Subject: Arun Retail Park, Unit D Shripney Road Bognor Regis PO22 9NF - BE/140/20/PL

Planning Application Reference: BE/140/20/PL

Proposal: Siting of 1 No. temporary storage container between 1st Nov and 31st Jan annually. This site is in CIL Zone 4 (Zero Rated) as other development.

PROPOSED SERVICE YARD LAYOUT PLAN
SCALE - 1:100

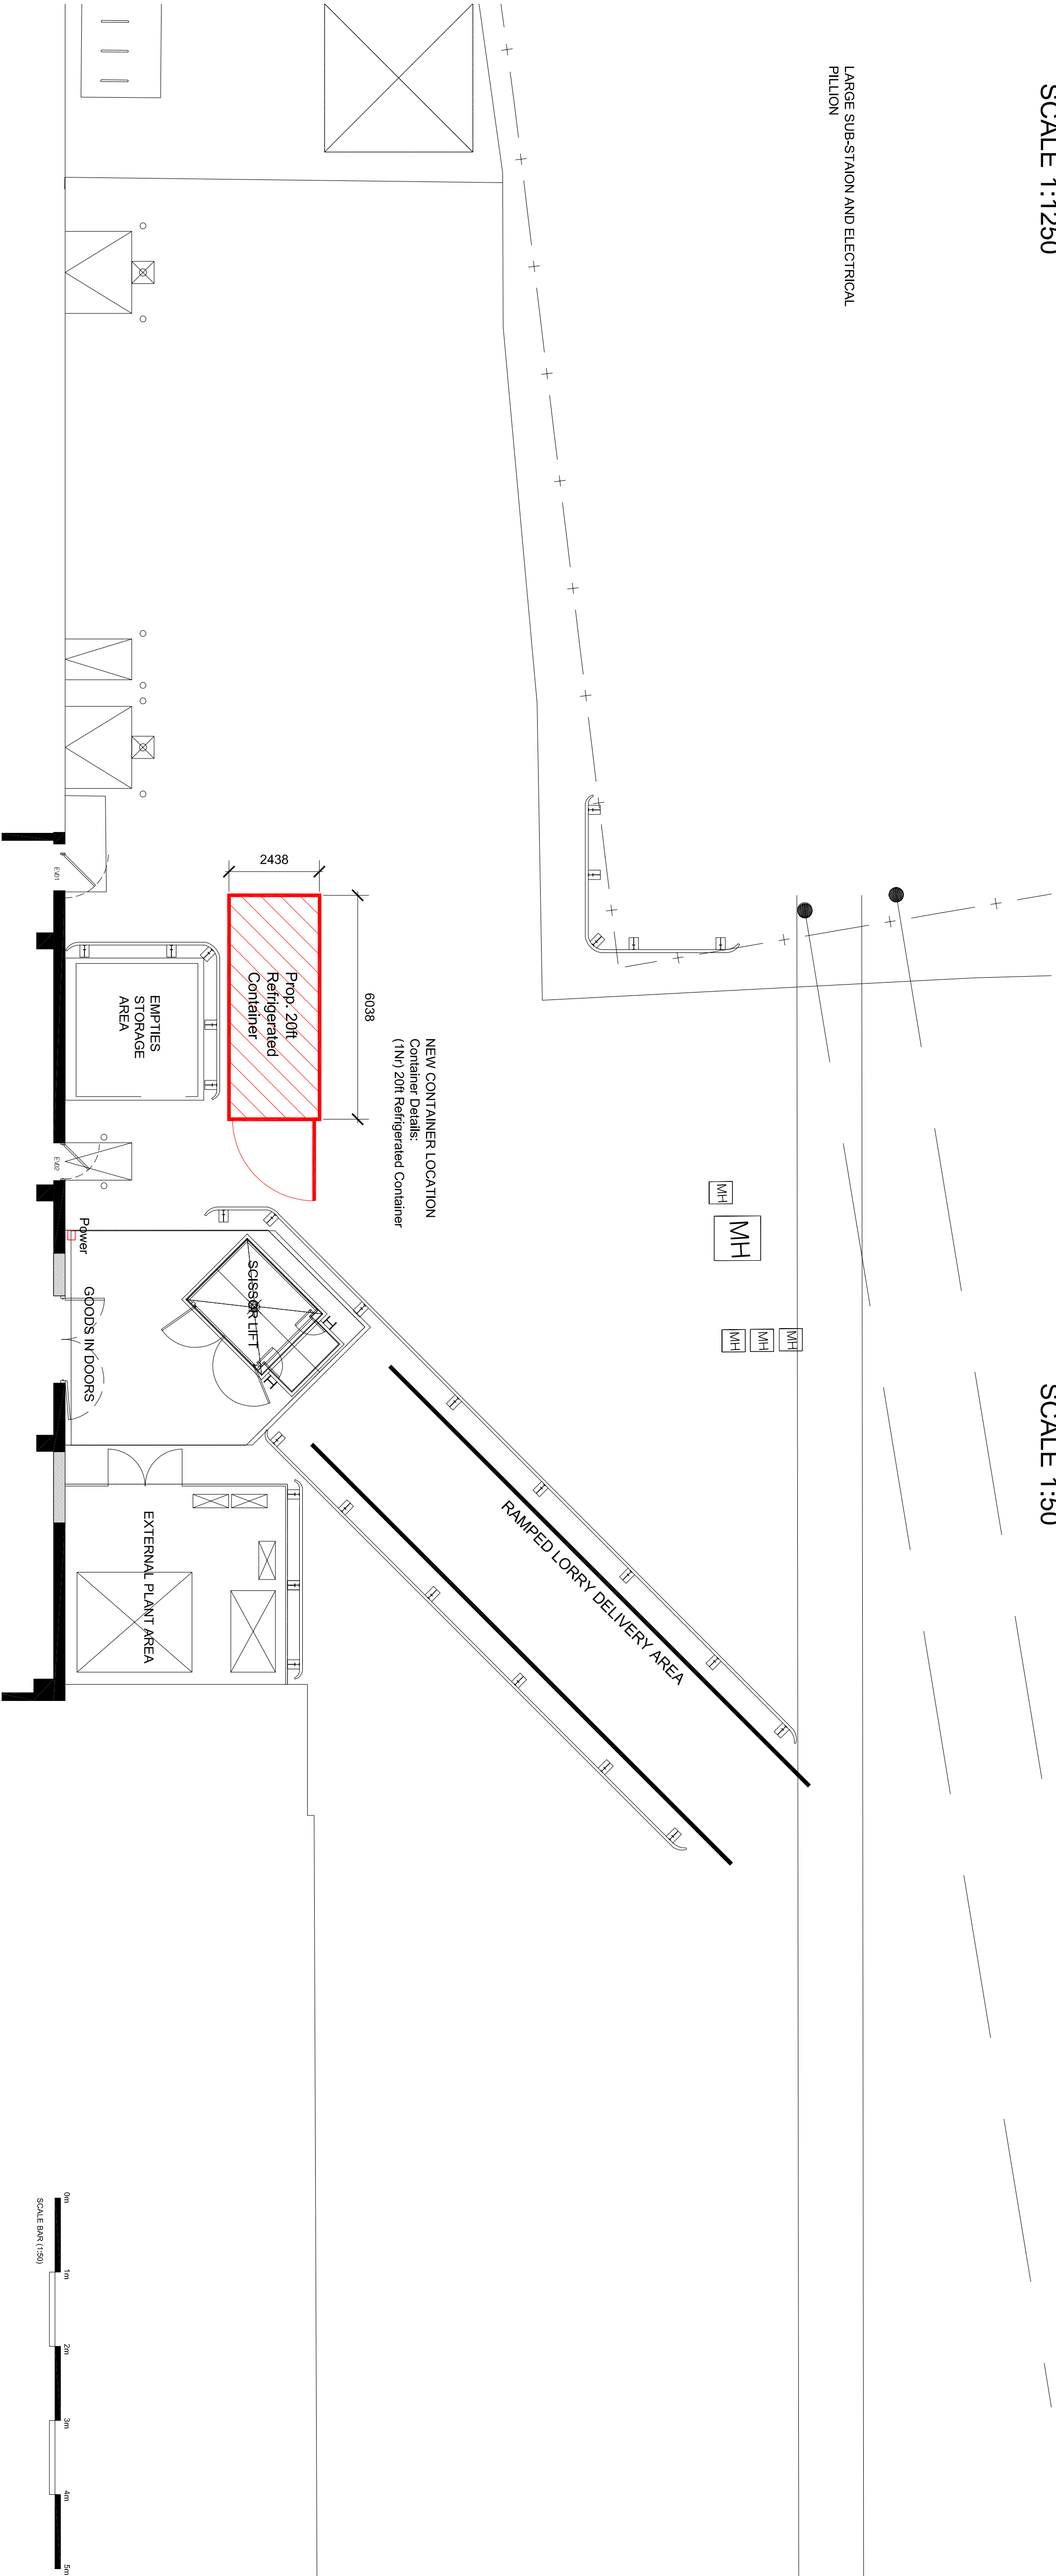
Should the installation of the proposed unit result in an increase of delivery vehicle or fork lift truck movements in the external area adjacent to residential properties, then a noise management plan shall be submitted for approval to the Local Planning Authority. The plan shall identify any noise sources and provide mitigation/control measures for the identified noise sources. The plan shall be implemented prior to operation of the proposed unit and maintained thereafter.

PROPOSED CONTAINER ELEVATIONS
SCALE 1:50

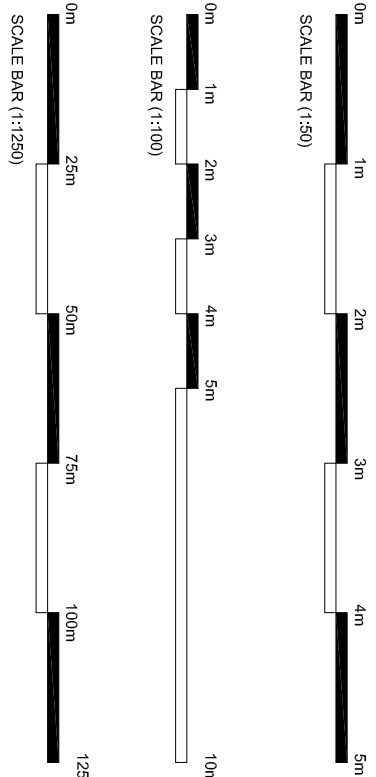
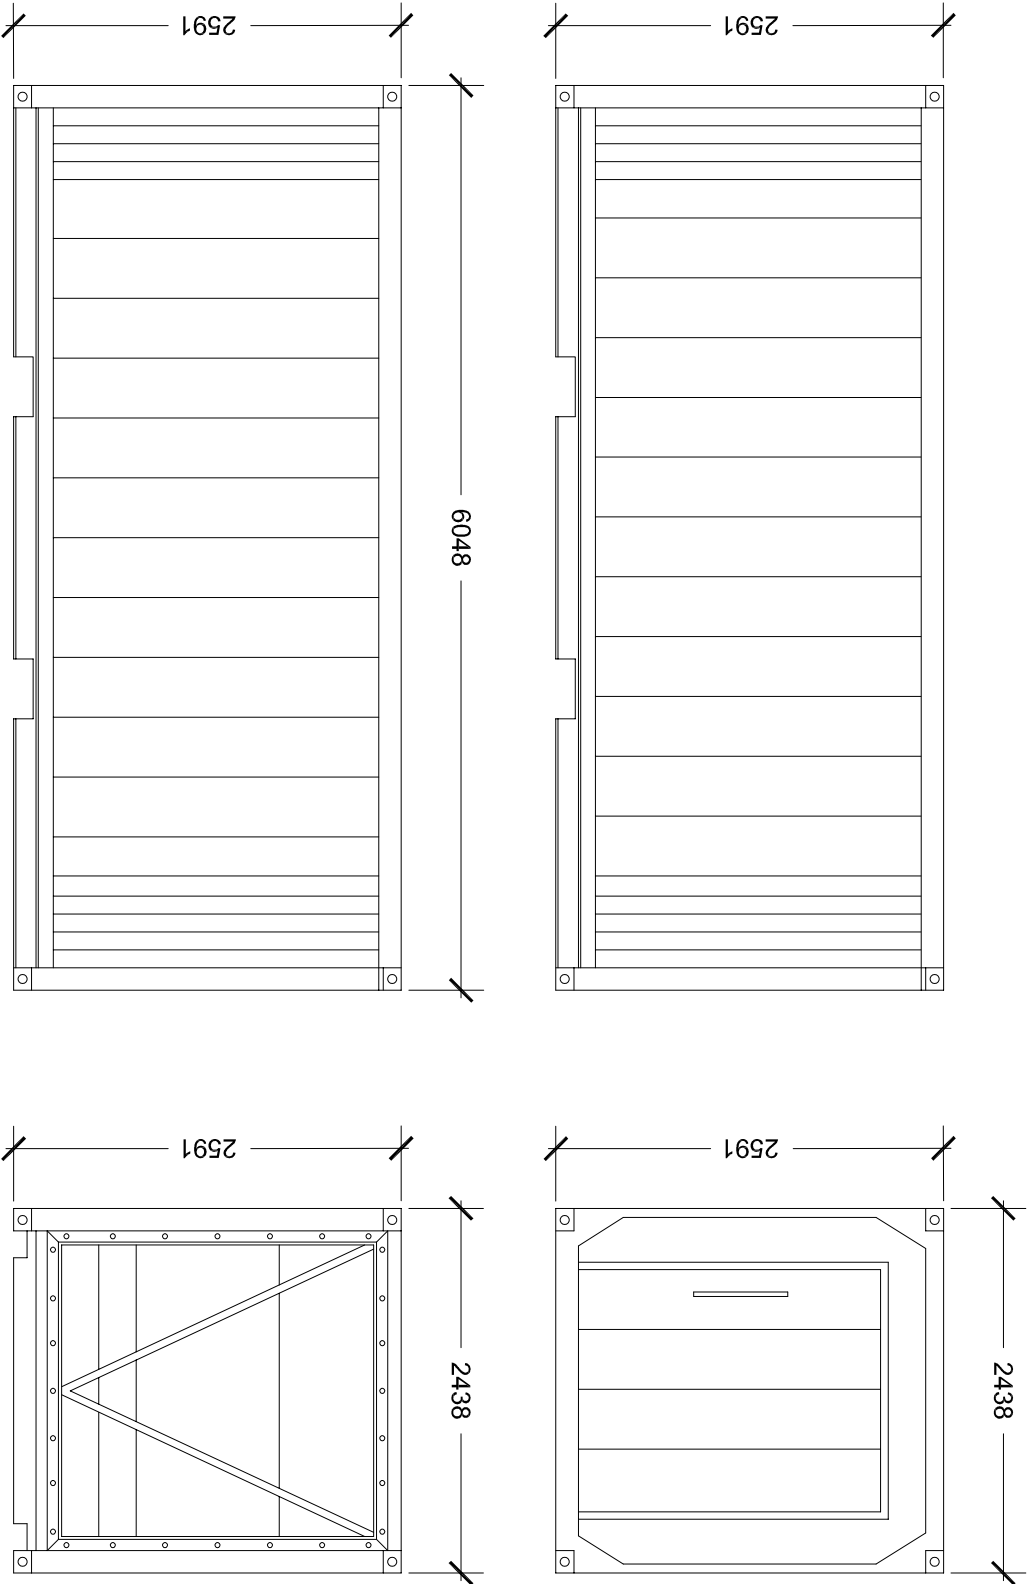
I note from the specifications of the proposed unit that the average noise level at 10 meters from the proposed unit is 45dBA. I note that the nearest sensitive receptors are approximately 30-35meters away. The noise level from the proposed unit does not exceed the lower threshold set by WHO guidelines for external amenity noise.

I therefore recommend that any permission granted be conditioned as such that noise levels from the approved refrigerated container unit do not exceed 45 dBA at a distance of 10 meters. The unit shall be maintained thereafter in accordance with manufacturer's instructions.
